Advice on Environmental Impact Statement – State Significant Development

Proposal: Junction Rivers Wind Farm

Major Project reference: SSD-30448824

In preparing this advice Heritage NSW has reviewed the following documents:

Figure 6-9 AHIMS Sites within the Subject Land

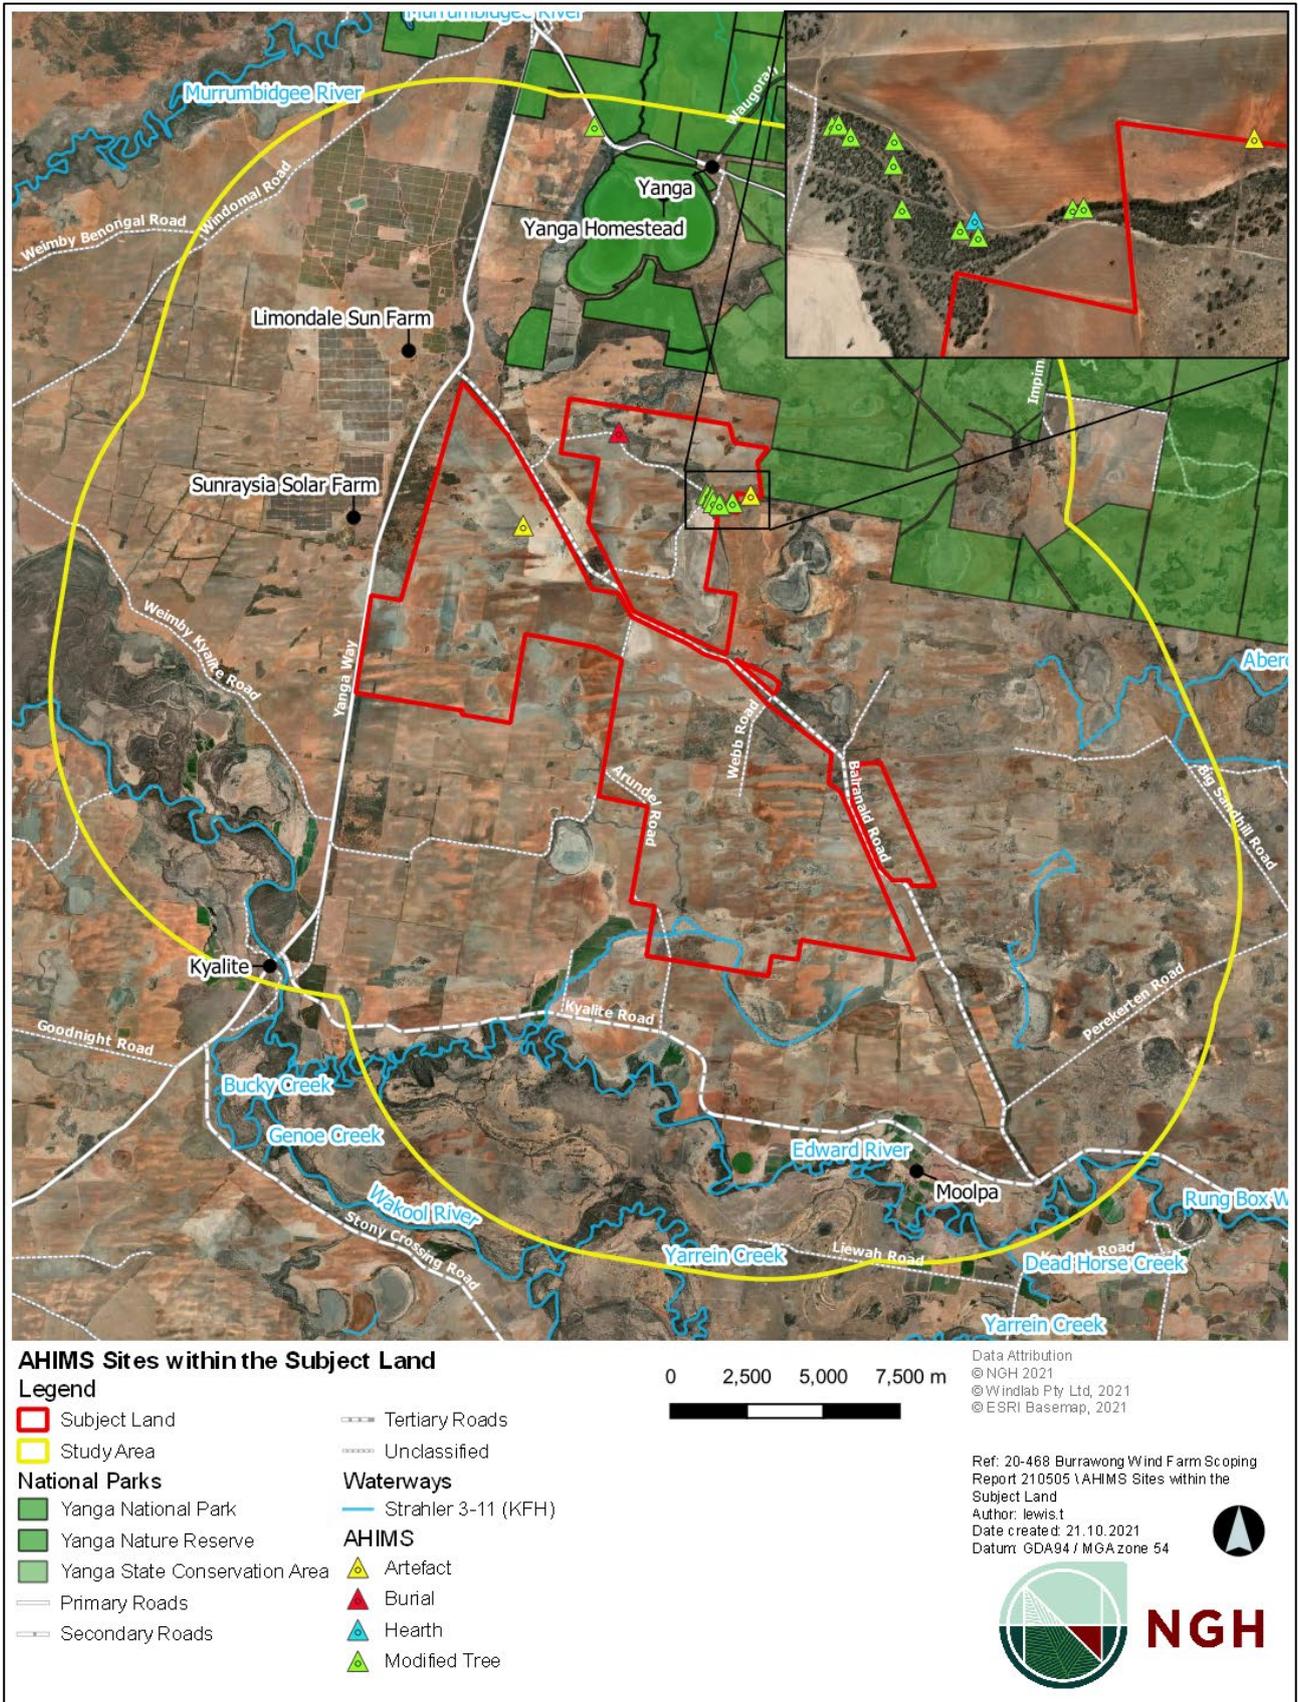
1. Please provide copies of the AHIMS extensive search results.
2. Please provide further explanation of the assessment of potential archaeological deposit (PAD) for the identified sites. For example, the Archaeological Technical Report Appendix A 'Site Descriptions', includes sites 47-6-1174 and 47-6-1175 both described as artefact scatters located on the basal slope of a red sandy rise in proximity to an ephemeral water source. AHIMS site 4-6-1193 is described as a hearth in the wall of a blow out with a nearby stone

artefact. The predictive model in the ACHAR describes these landforms as areas of high archaeological potential.

Please provide an assessment of the surrounding landform of all the identified sites for potential subsurface archaeological deposit, as well as a detailed explanation in relation to the potential for subsurface material, and justification as to why test excavations should not occur prior to construction in the project area. Should adequate justification not be provided, Heritage NSW recommends that test excavations occur prior to any construction impacts in the project area.
